Lake House – Corrections Response Letter

Building Plan Reviewer: **City of Mercer Island**

Response to: 2012-200 Lorenzini Remodel 2R
Dated: June 17, 2021
Permit #: 2012-200
Project address: 3310 97th Ave SE
Mercer Island, WA 98040

Re: *Lorenzini Remodel (Lake House) at 3310 97th Ave SE Permit No. 2012-200*

SITE PLAN
A1.01

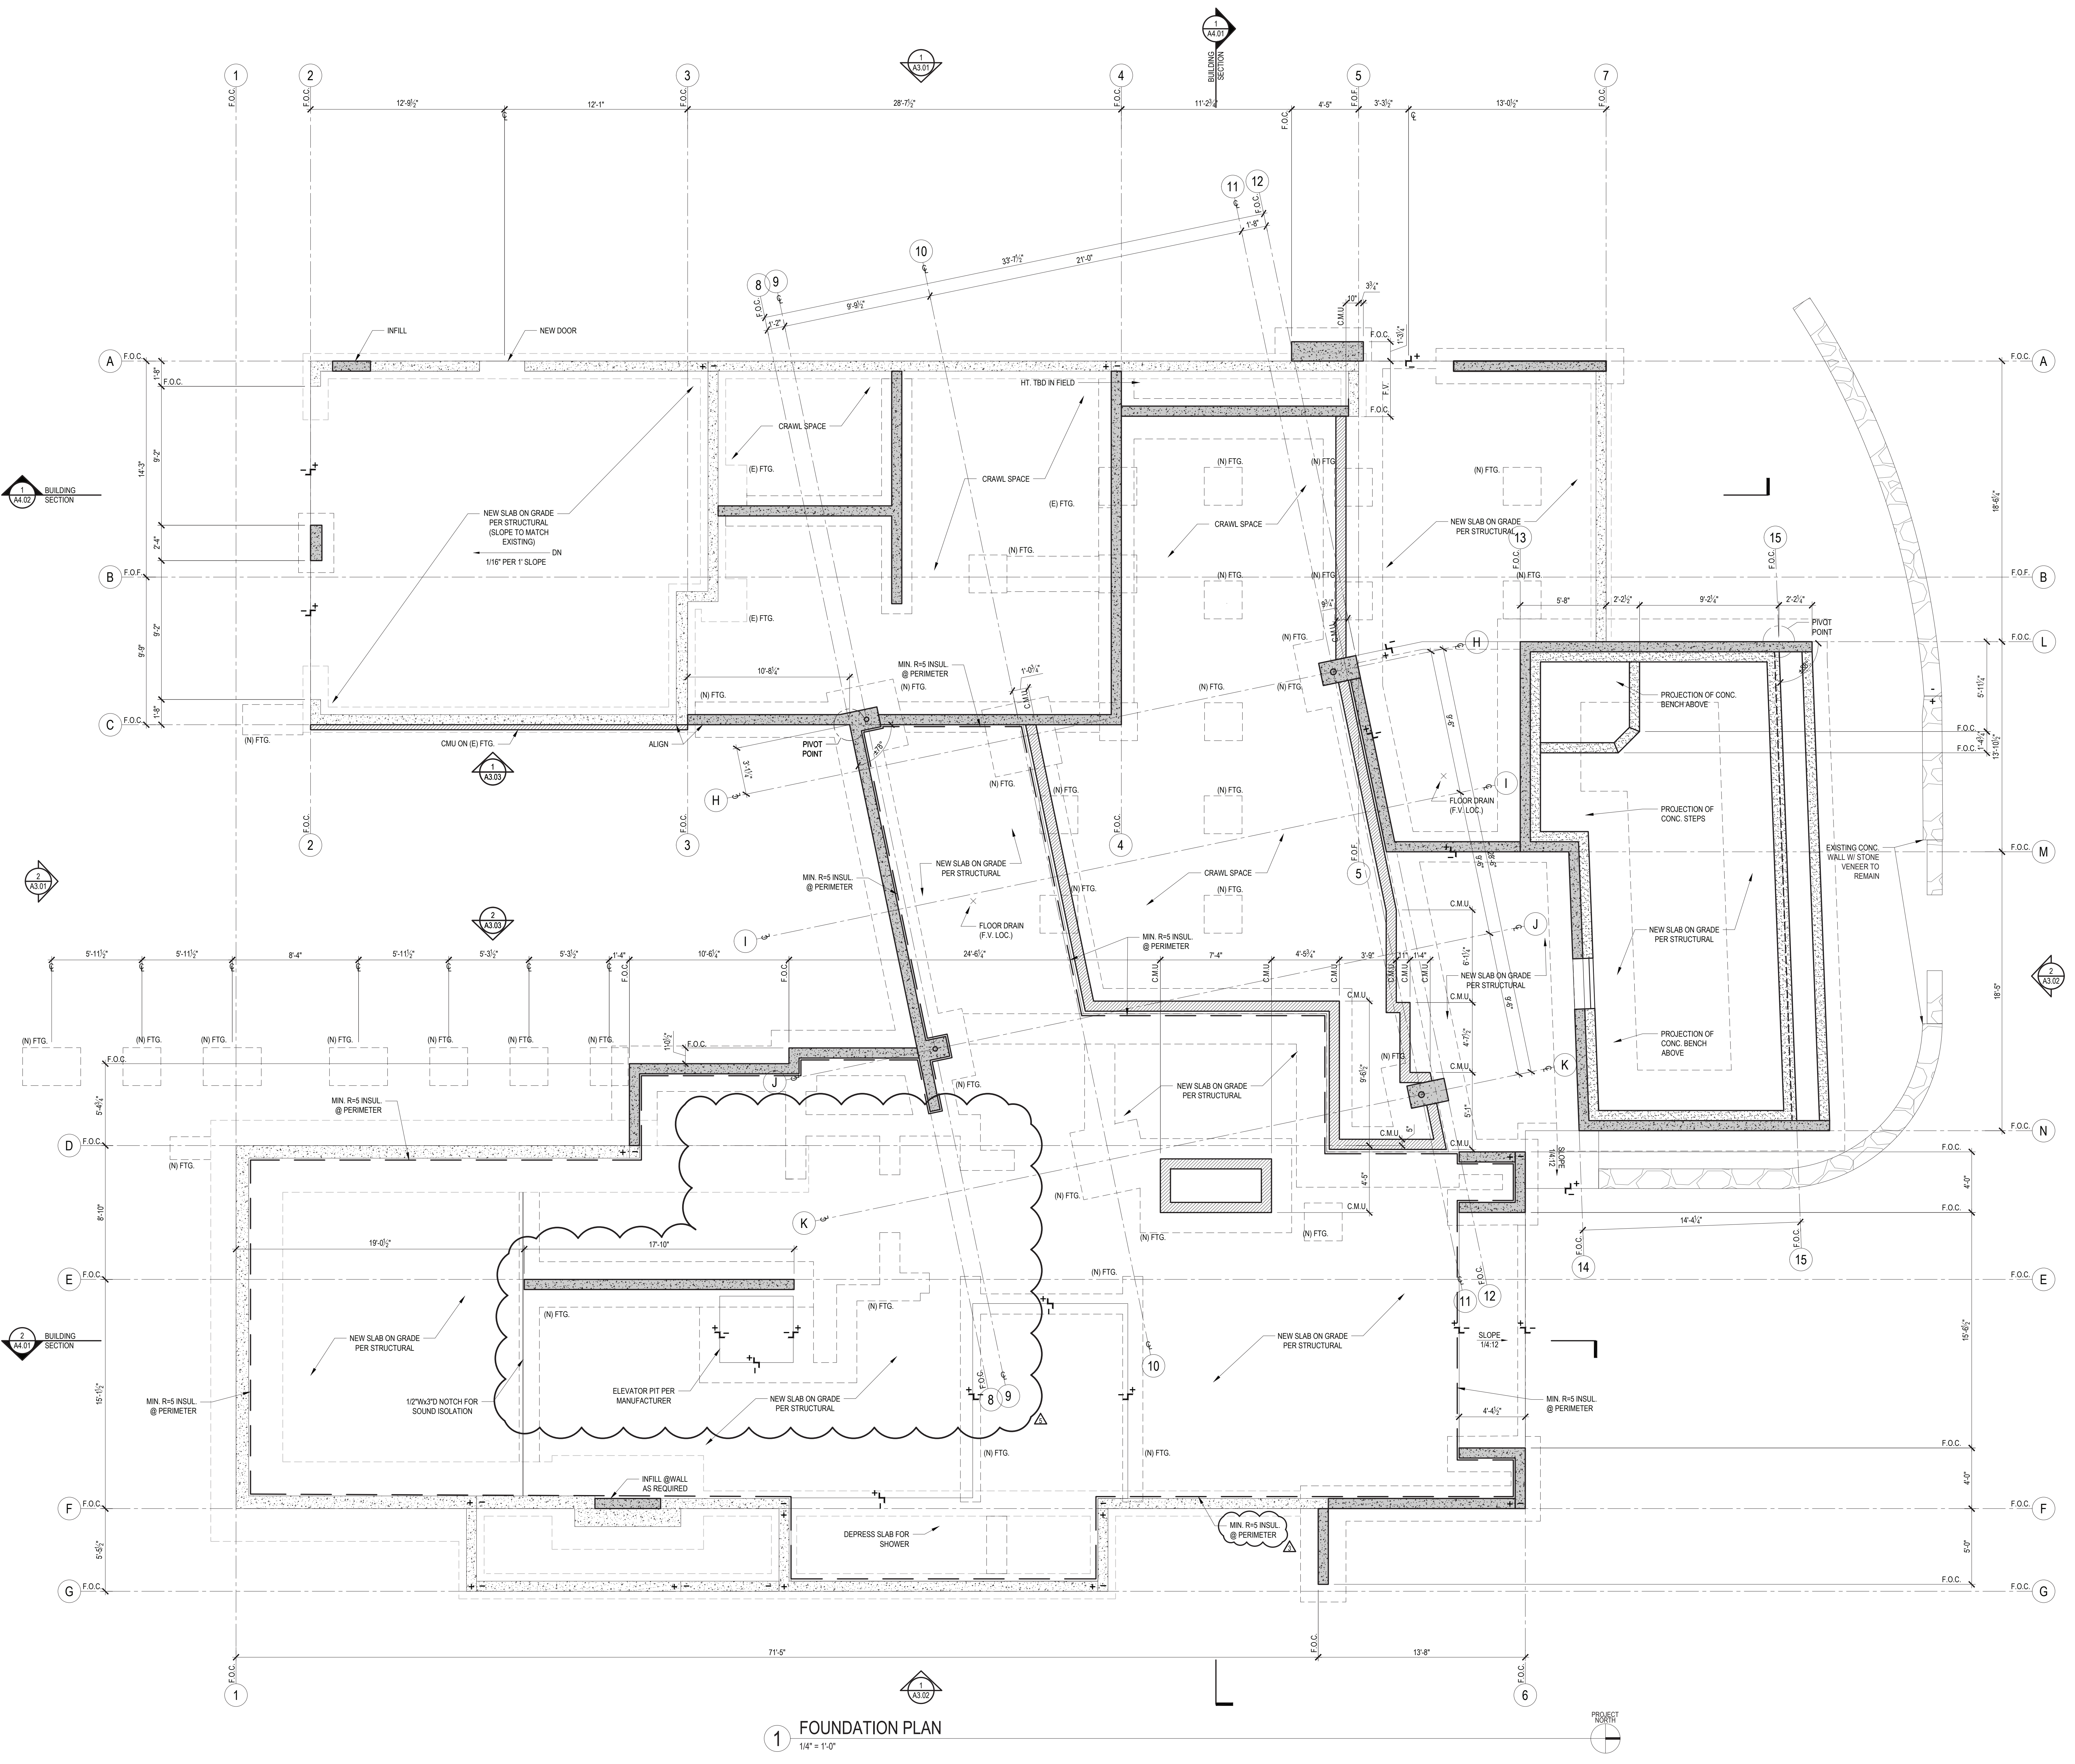
9. It appears the roof area of the A1 vented space is incorrect in the table on Sheet T1.02. It should be revised to coordinate with the plan.

See T1.02 for updated diagram and calculations.

MAIN LEVEL FLOOR PLAN
A2.03

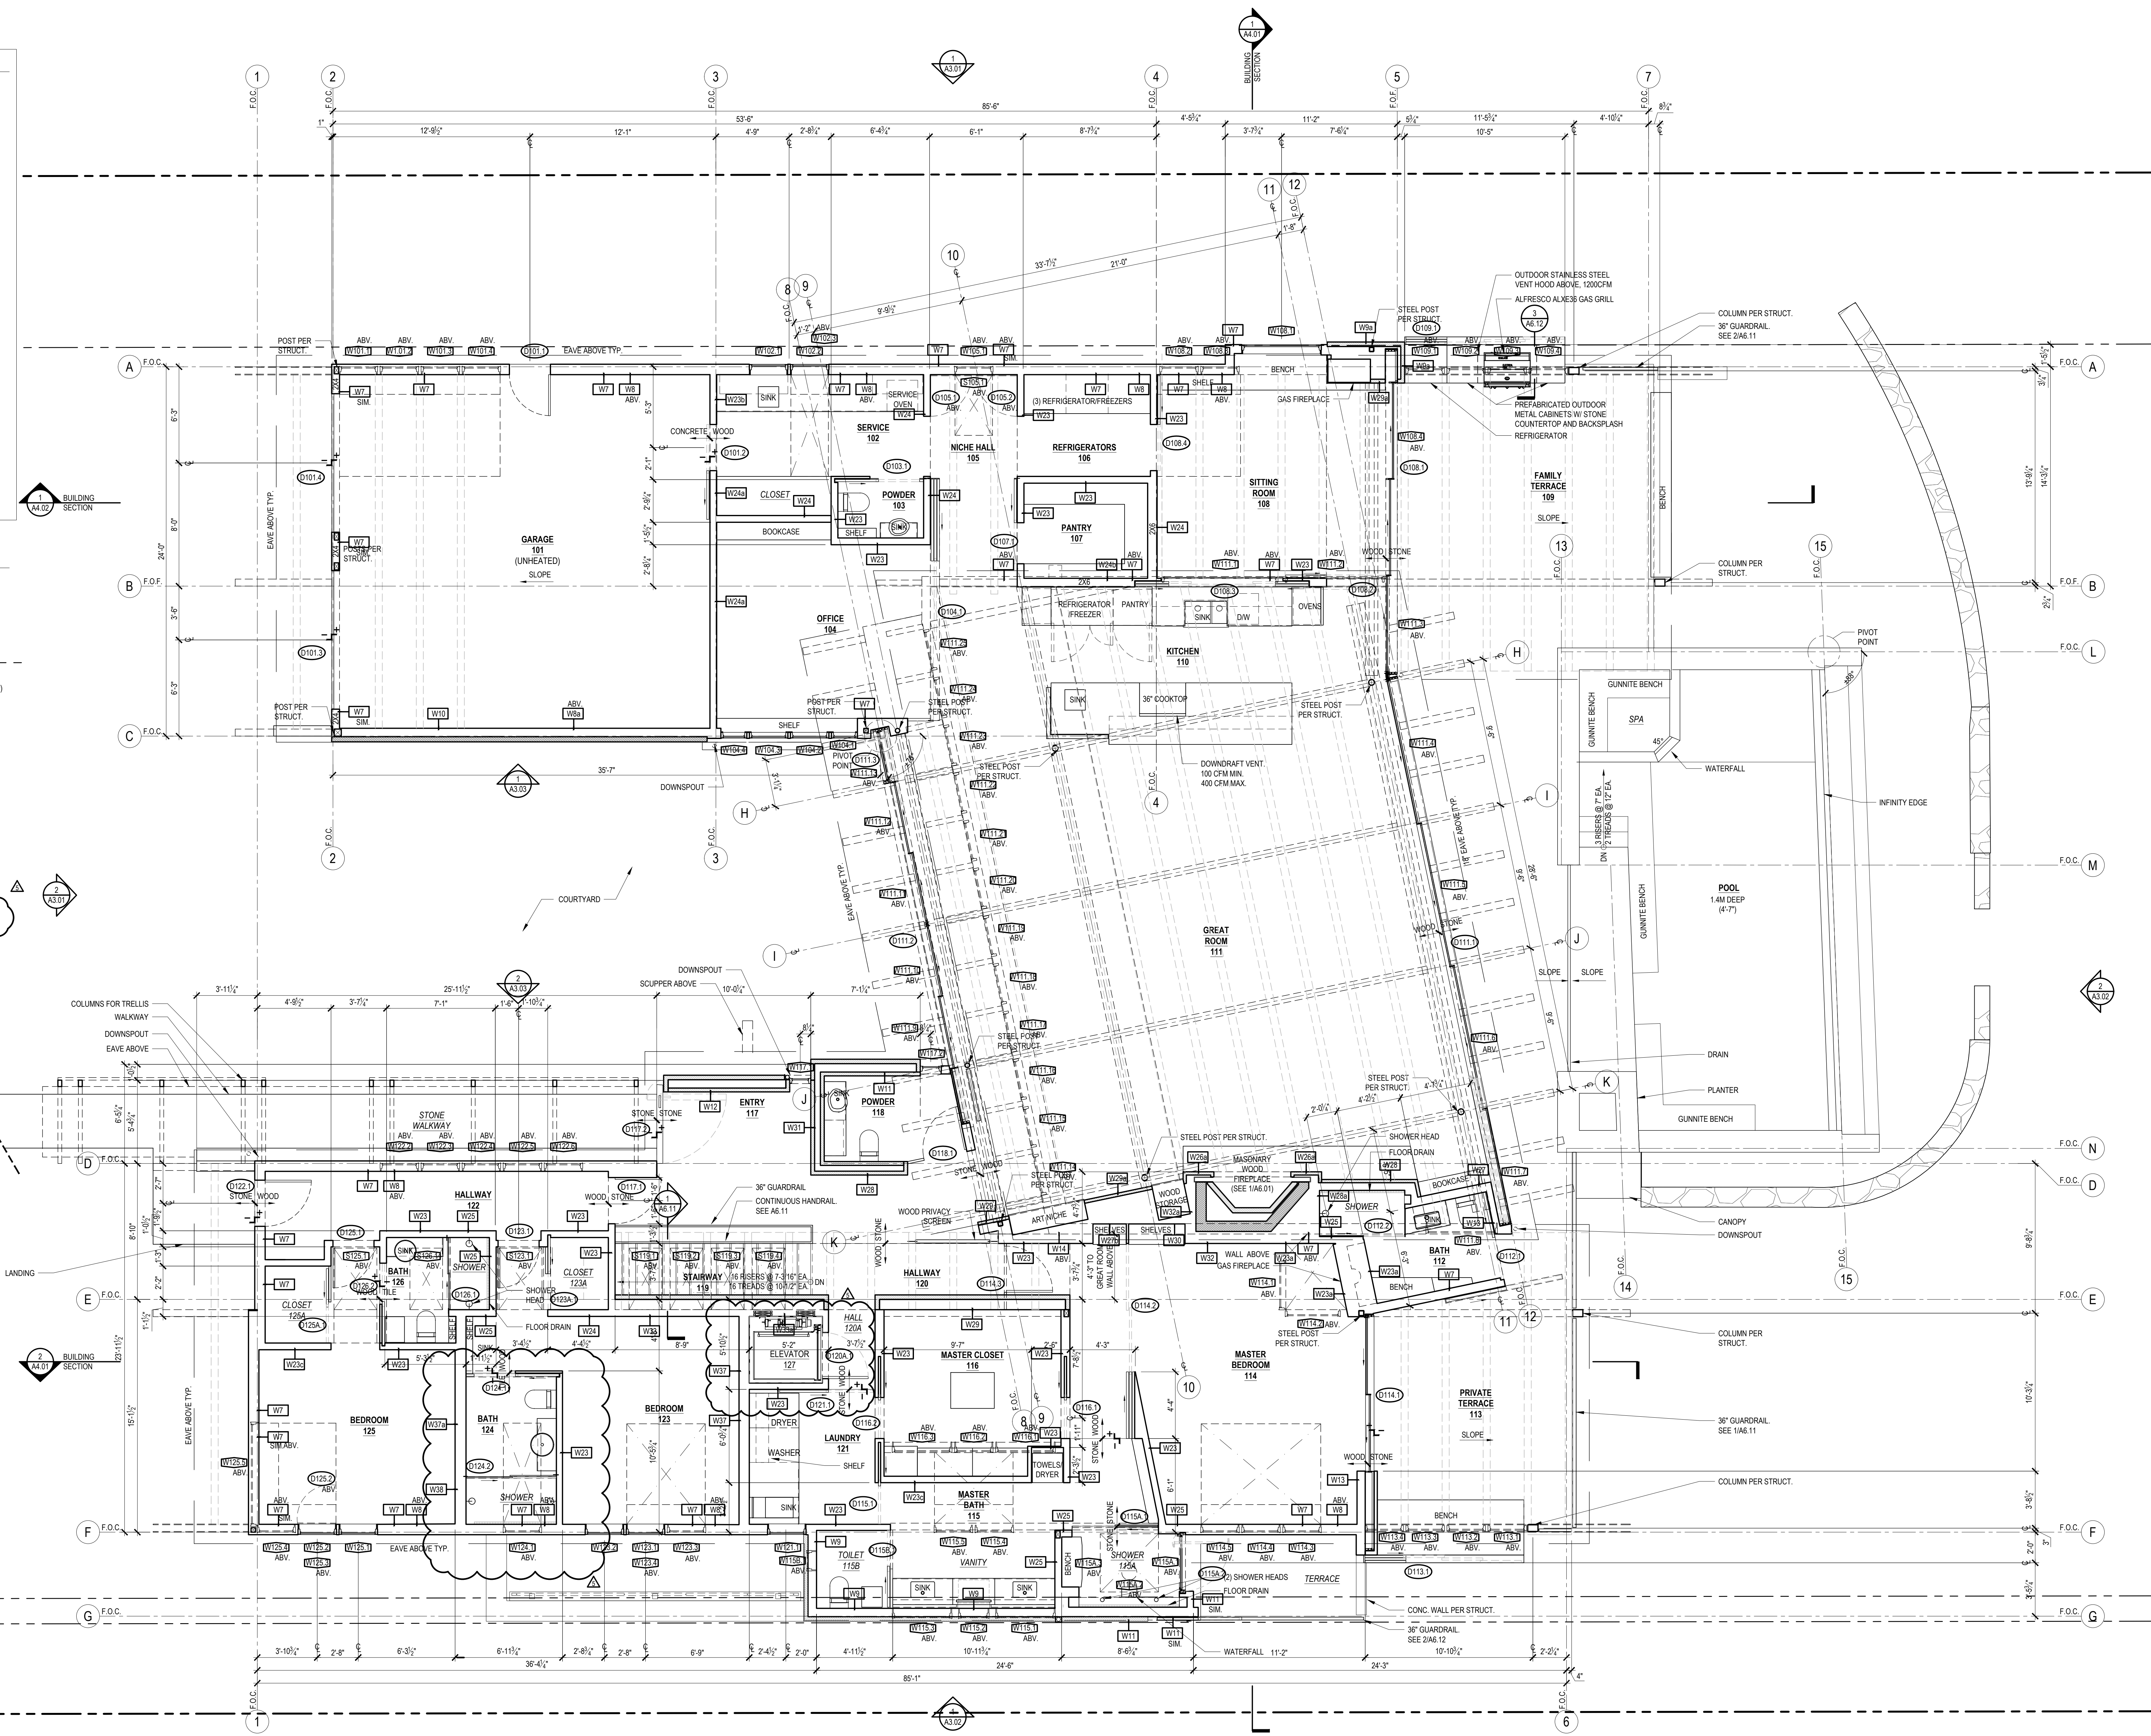
13. Clarify if combustible framing is intended around the exterior BBQ at Family Terrace 109 (i.e., at the cabinetry). Provide a section through the BBQ bump-out area and detail framing configuration.

- See additional notes around the BBQ on A2.03 1/A3.01, 2/A3.02, 1/A4.02

1 BUILDING SECTION
1/4" = 1'-0"

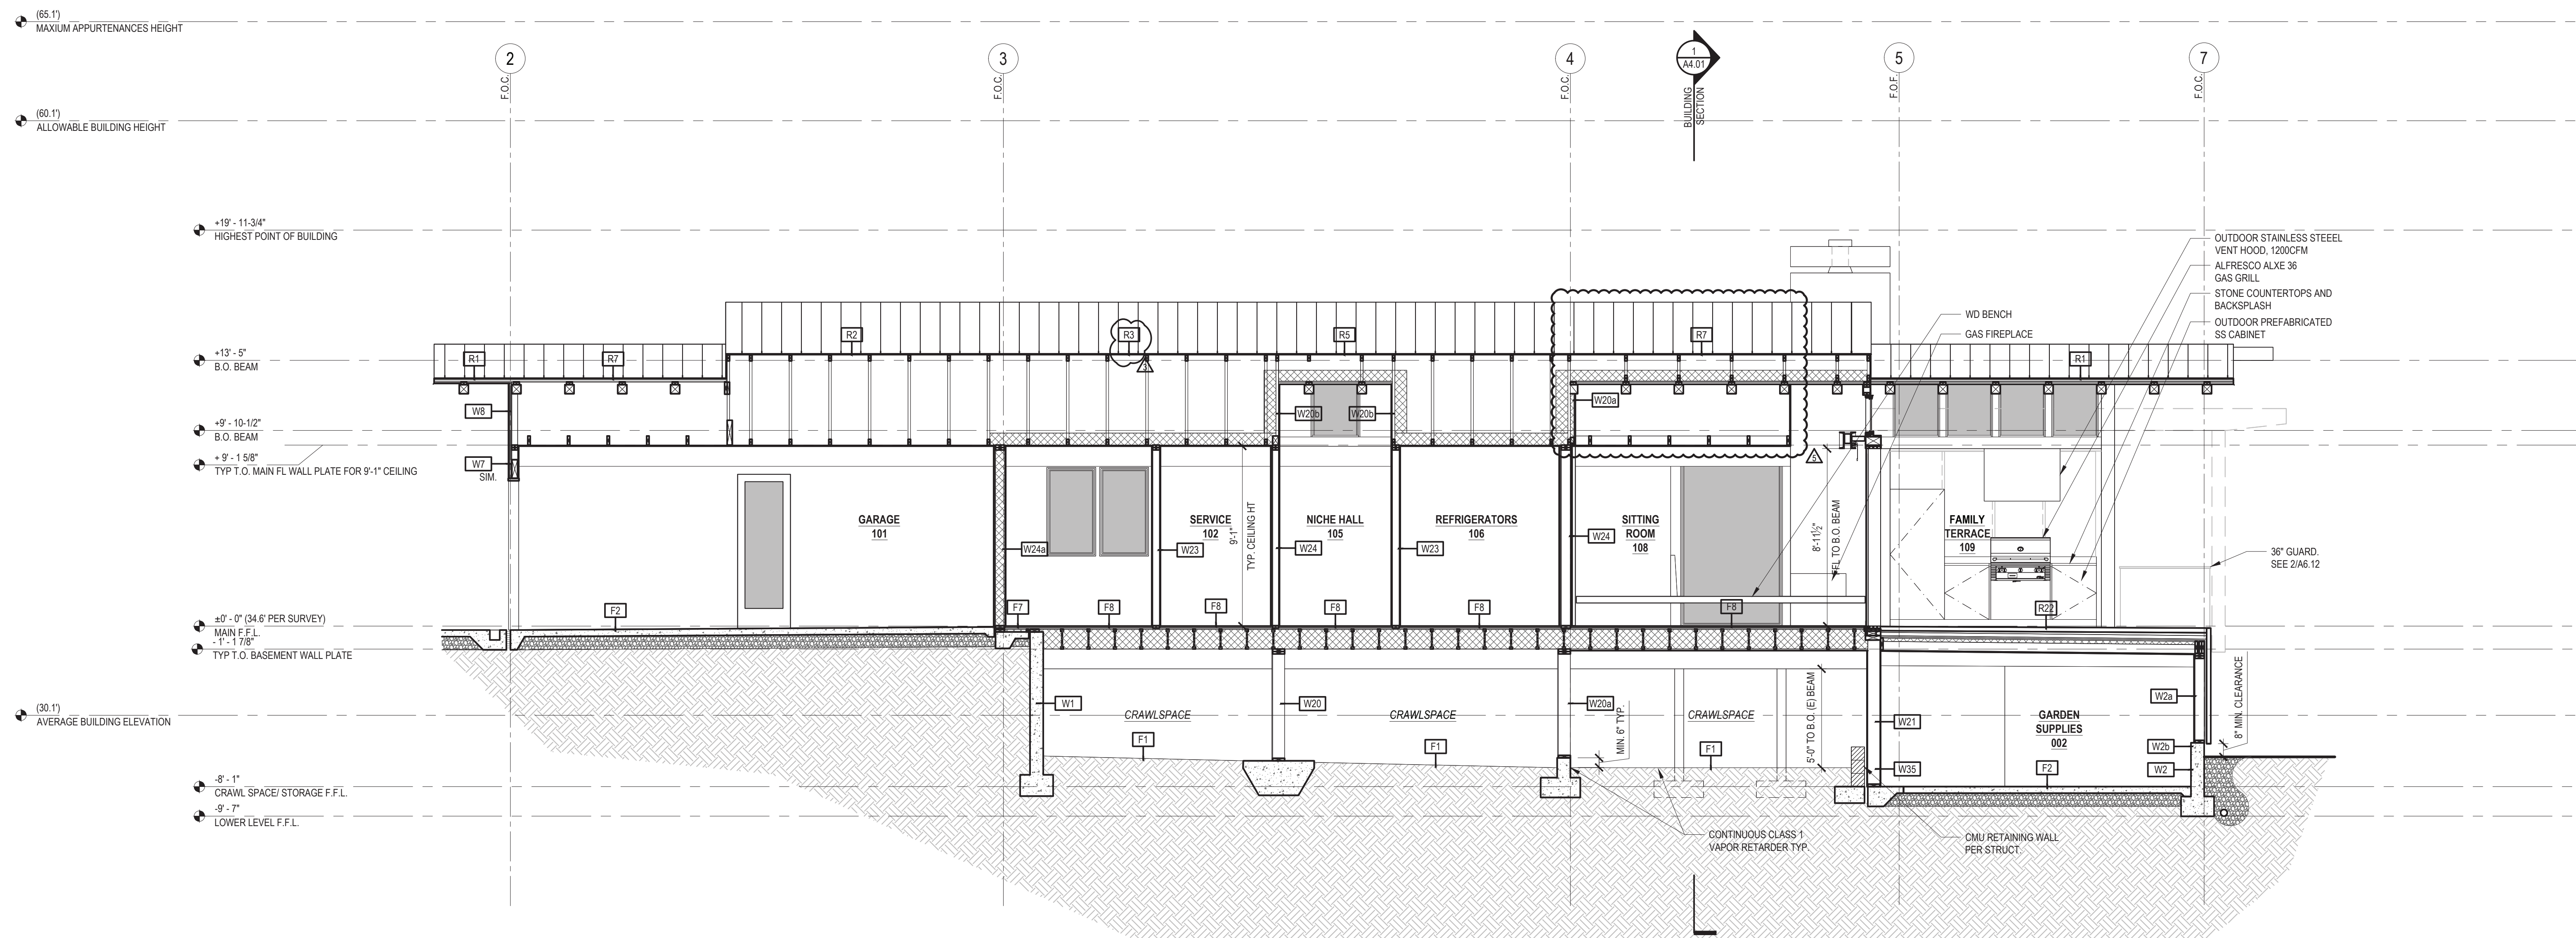
8. At the masonry fireplace, the ash dump cleanout requires a ferrous metal door and frame per IRC R1001.2.1. Clarify how ash removal is to be accomplished. See overall fireplace section in Building Section 1/A4.01.

5. Specify an insulated roof assembly at the portion of roof that extends past Grid A at Sitting Room 108 as depicted in Building Section 1/A4.01.

6. The building thermal envelope would be around Infrared Sauna 007. Wall Types W22a & W34a as shown in Building Section 1/A4.01 should be insulated. Additionally, clearly show how slab-on-grade is insulated with thermal break per IRC R402.2.9.

Ash dump is removed. See A6.01

Roof type tag was added to the portion of roof in 1/A4.01

- See A2.02 and 1/A4.01 for updated west wall of Sauna007, which are W22a &W34.

- See updated thermal break notes in A2.01 and A4.01. No other detail is required.
